PPR-22-035 18065 Saddlewood Road Agritainment Site Development Plan

SITE DEVELOPMENT PLAN CHECKLIST

COLORADO KIDS RANCH LANDSCAPE PLAN

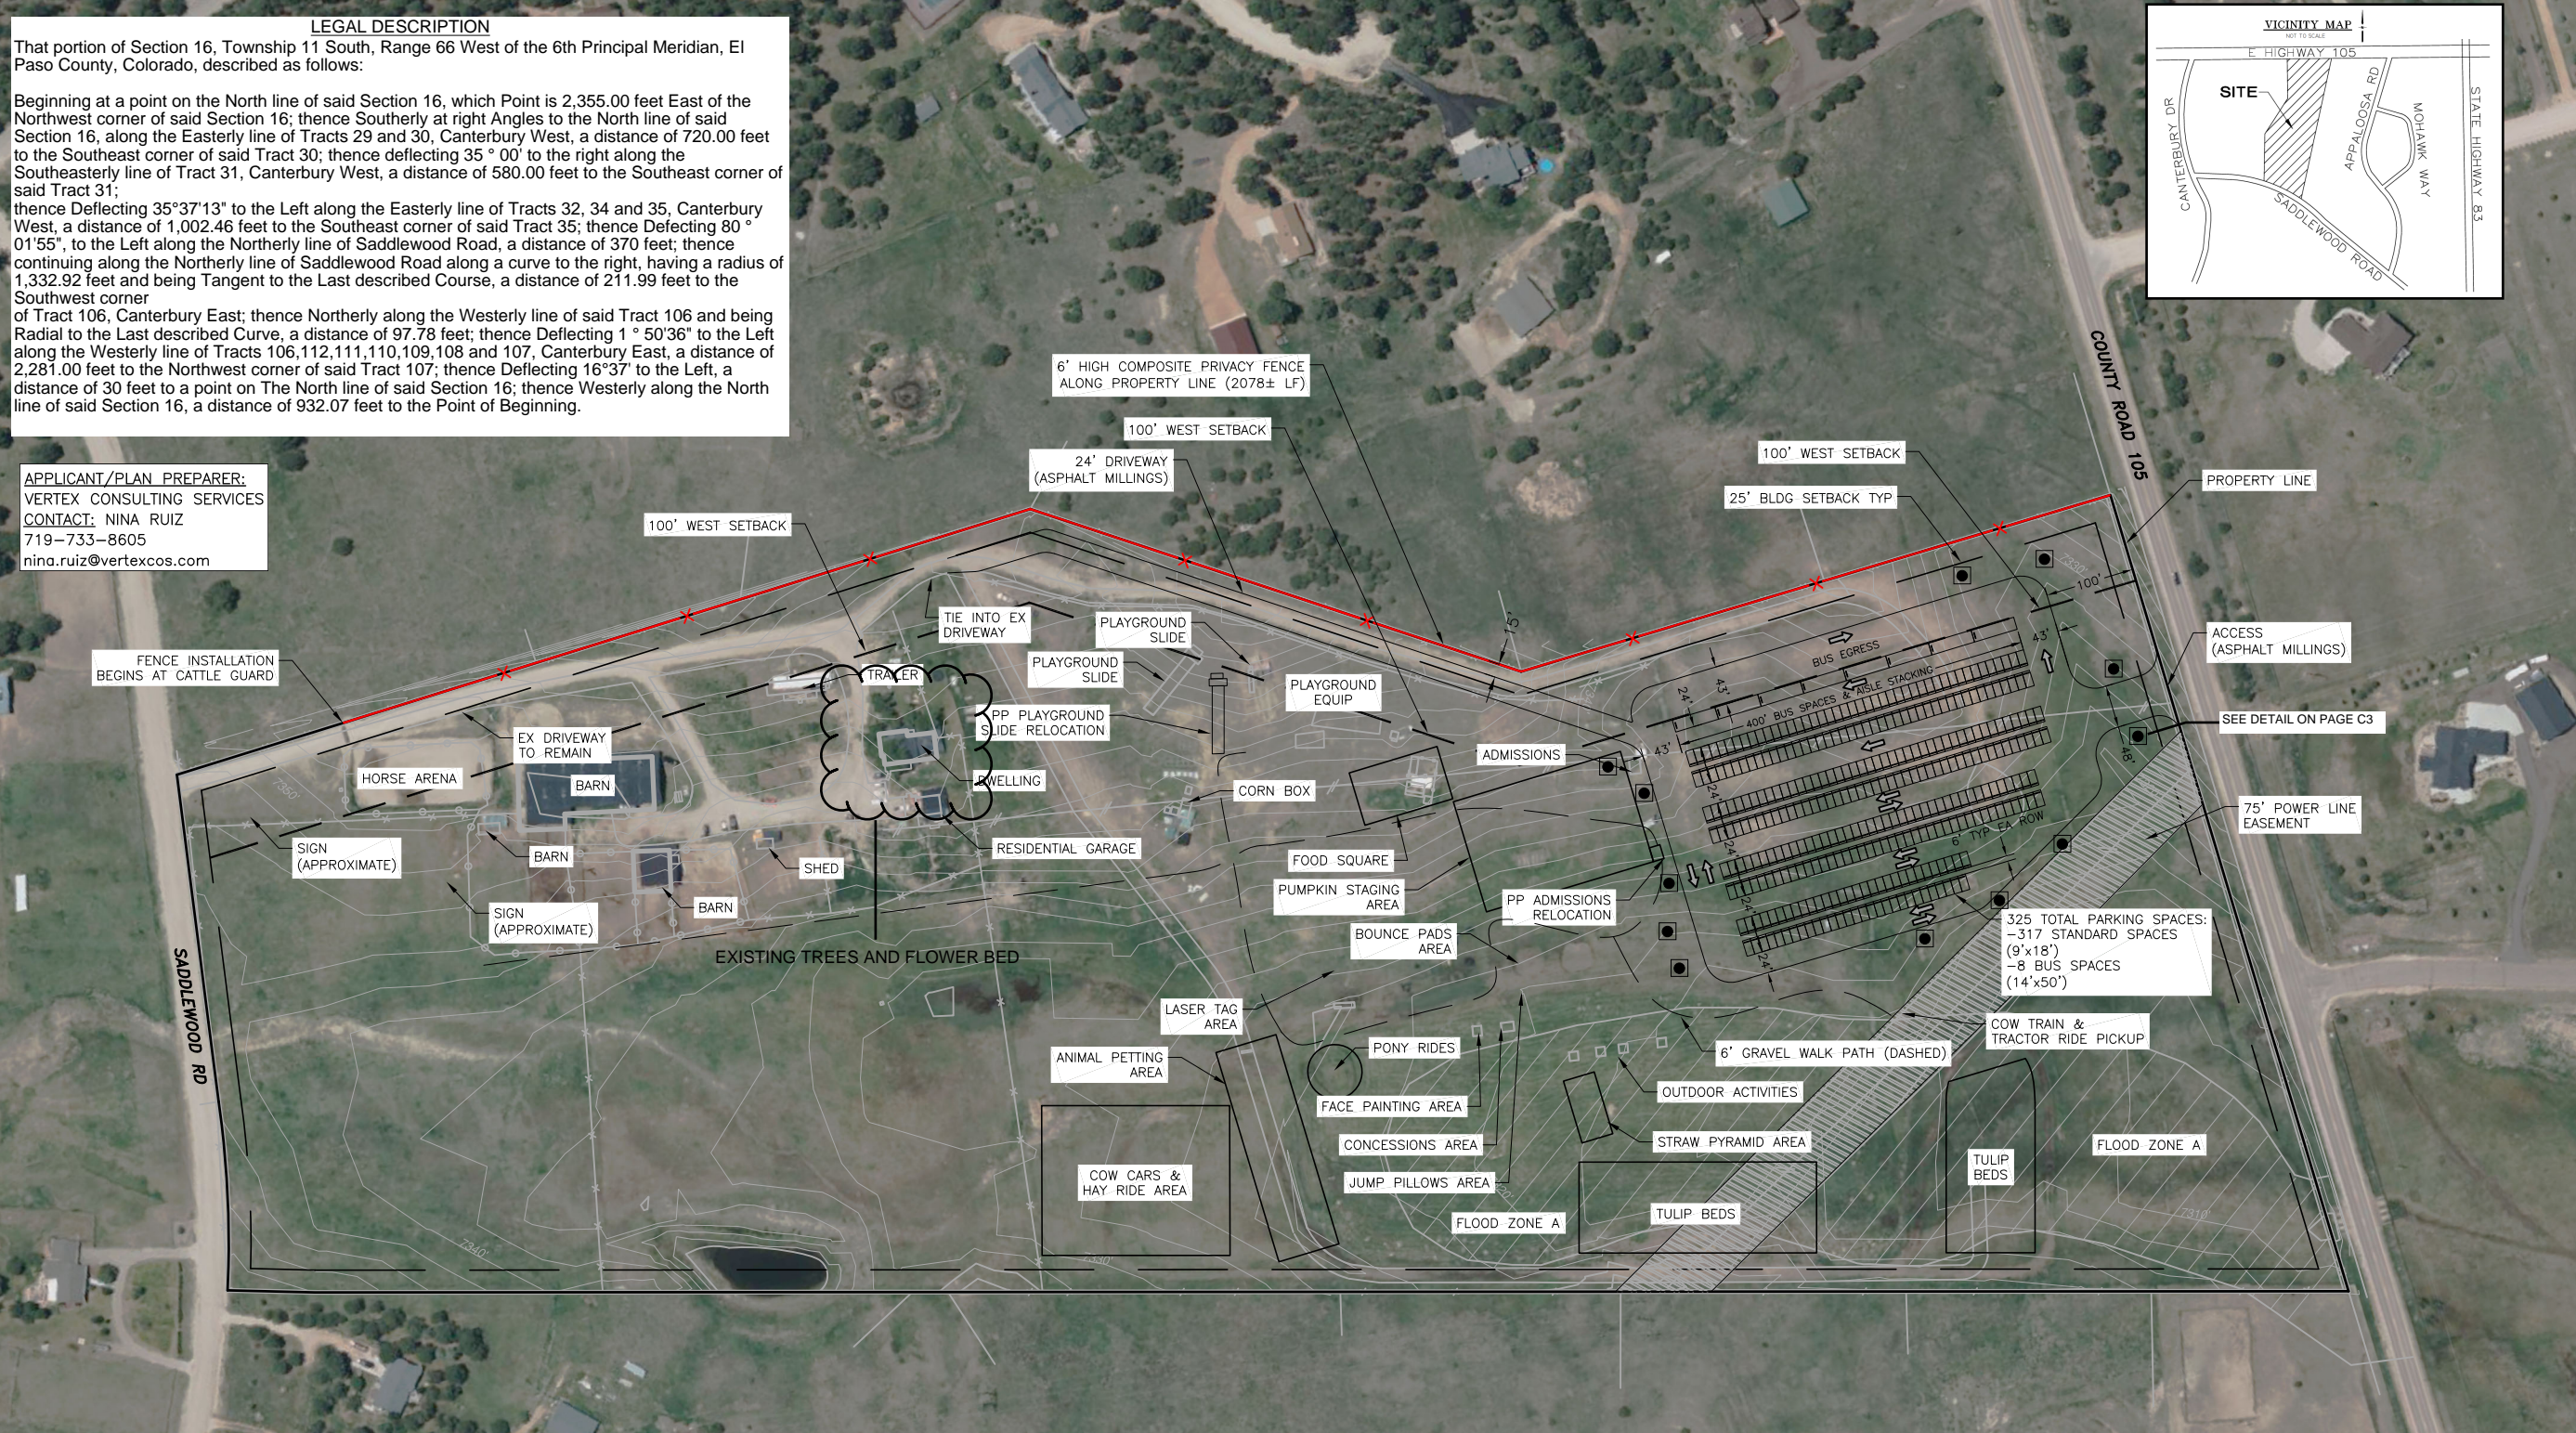
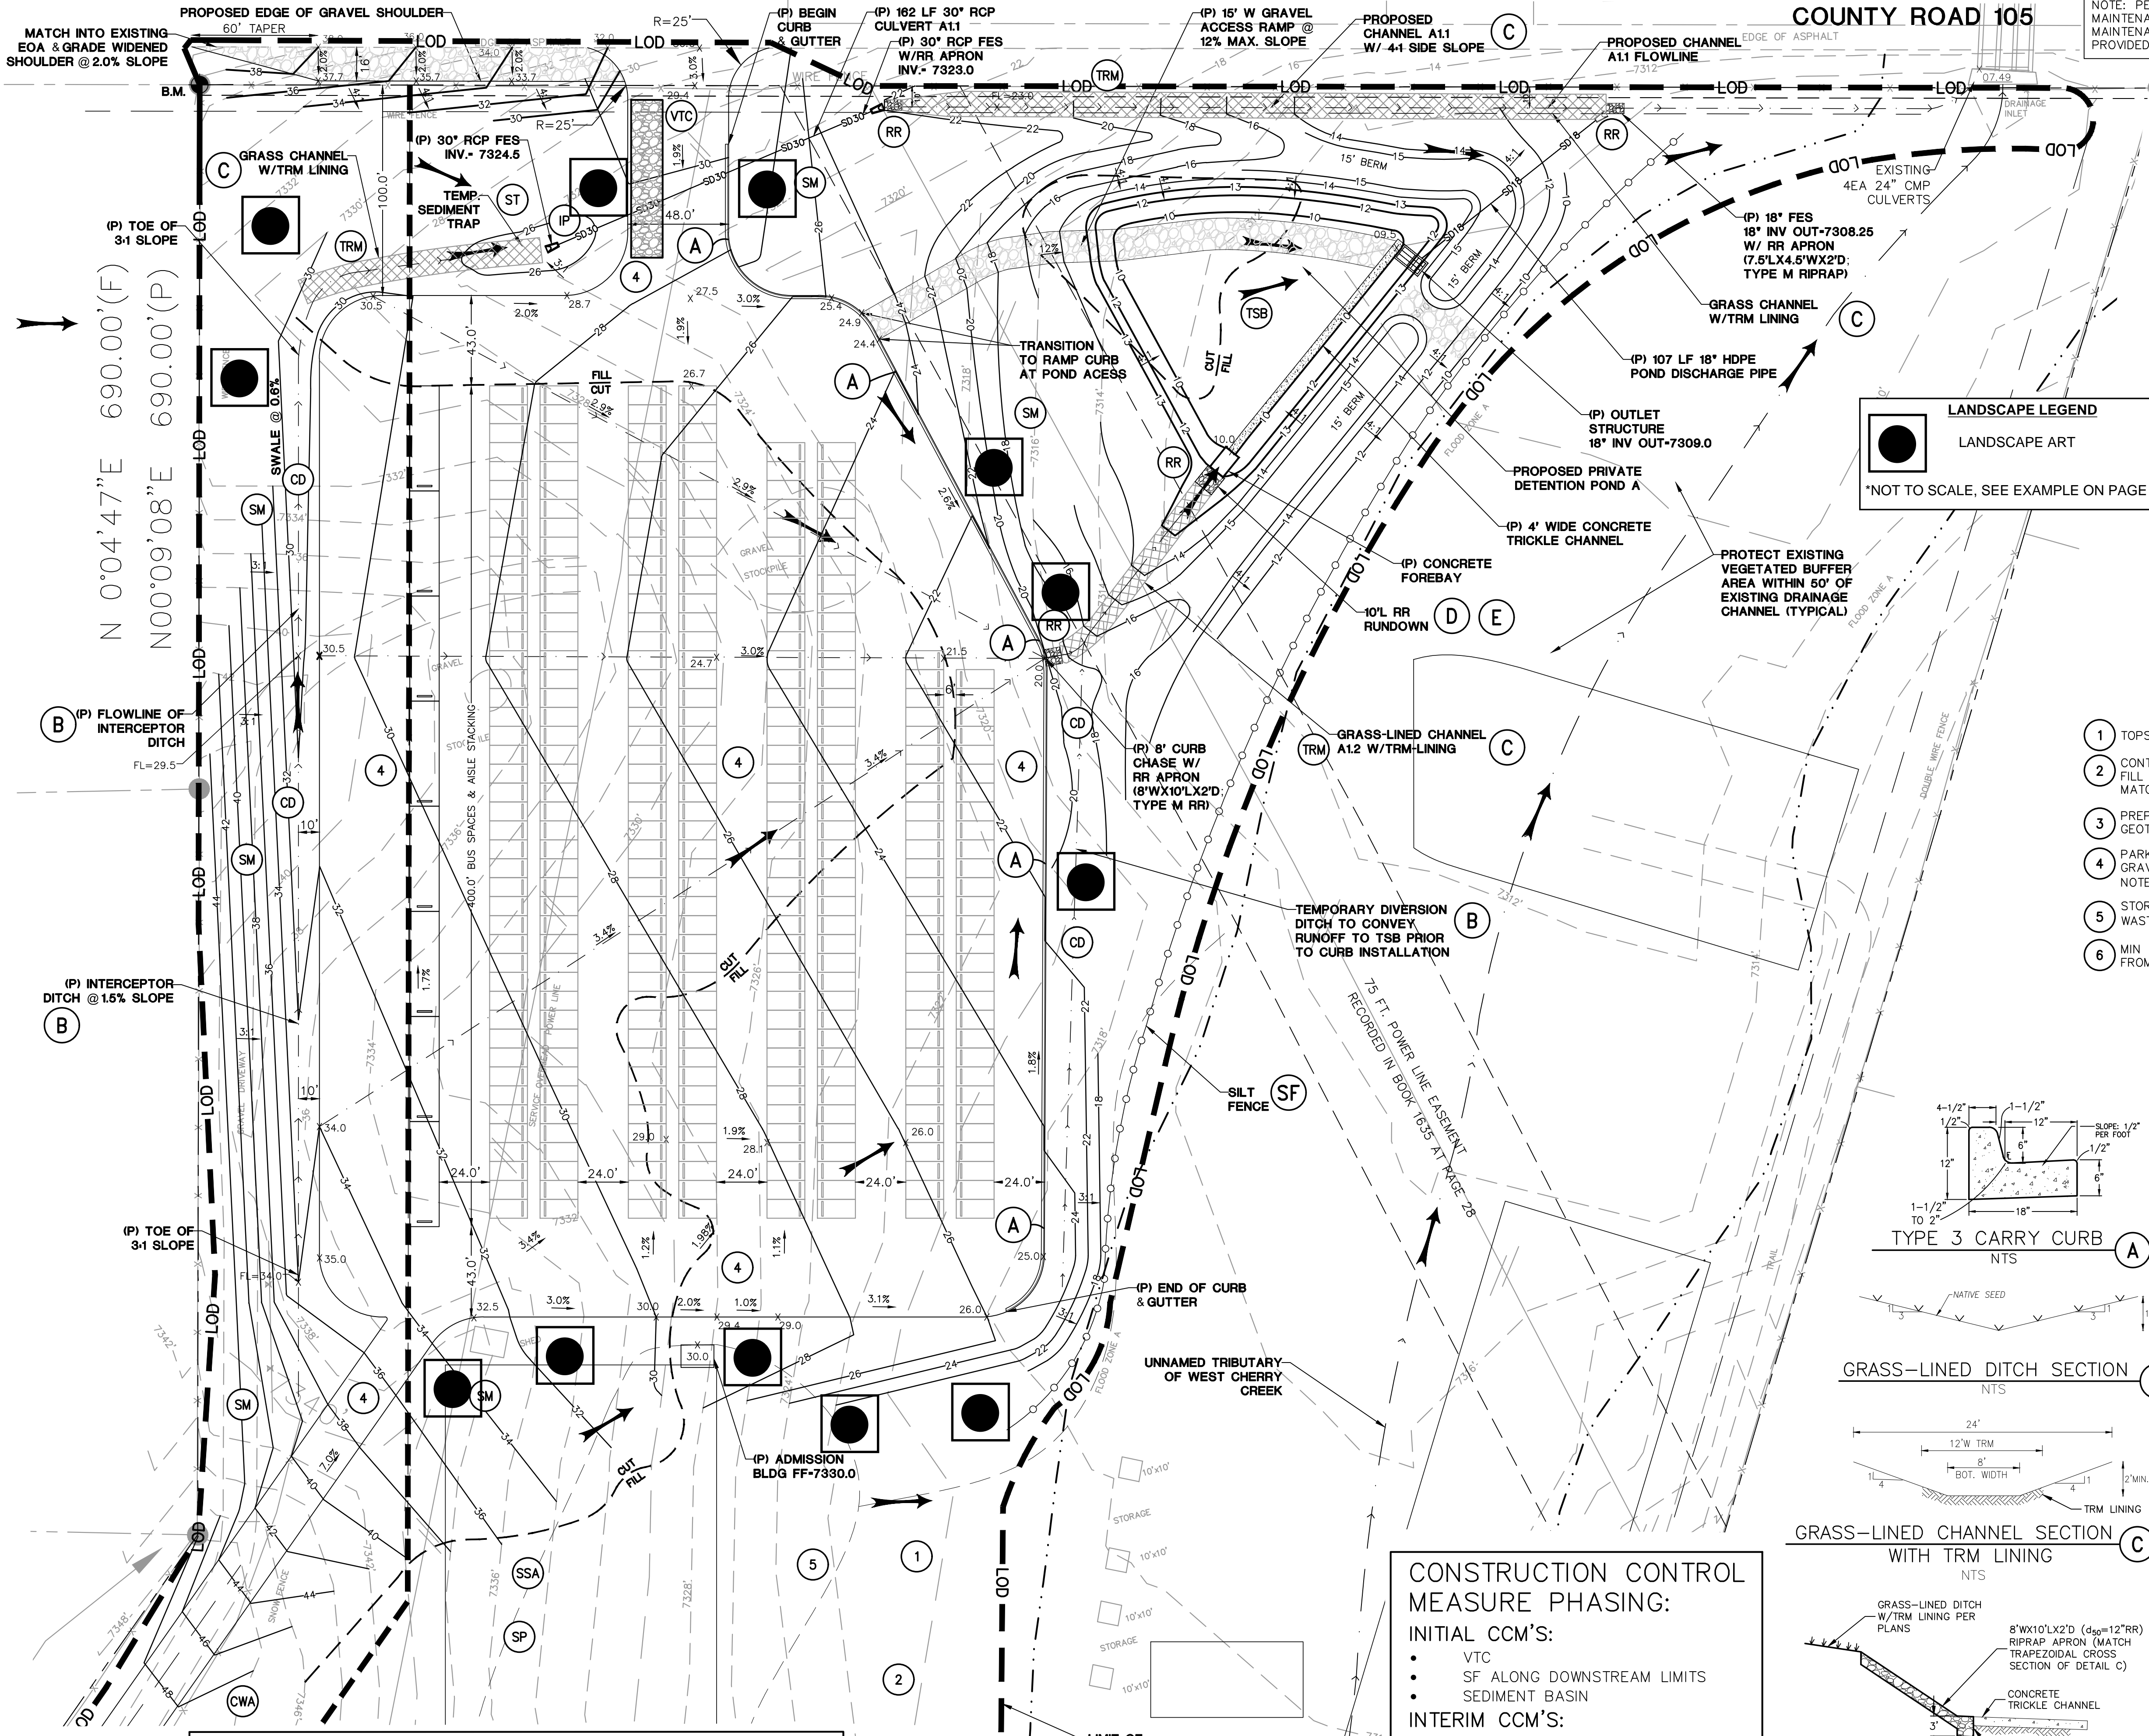
10	The layout and location of all landscaping, including landscape setbacks, unless otherwise depicted in detail on a separate landscape plan. If depicted on a separate landscape plan then depiction of the landscape areas are required.		No
11	Location of all ADA spaces, ramps and signs, including ADA pathways		No
12	Location of existing and proposed water and wastewater infrastructure, including well and septic locations, if applicable		No
13	Location of all no-build areas, floodplain, drainageways and facilities		Yes, more details required
14	Location of all garbage receptacles with a graphical depiction of the screening mechanism		No
15	Location of all existing and proposed utility lines and associated infrastructure		No
16	Any additional information required pursuant to any associated conditions of approval or plat notes.		No plating, 35+ acres
17	Any other additional items as required by the PCD Director deemed necessary to address the applicable review criteria:		Pending review
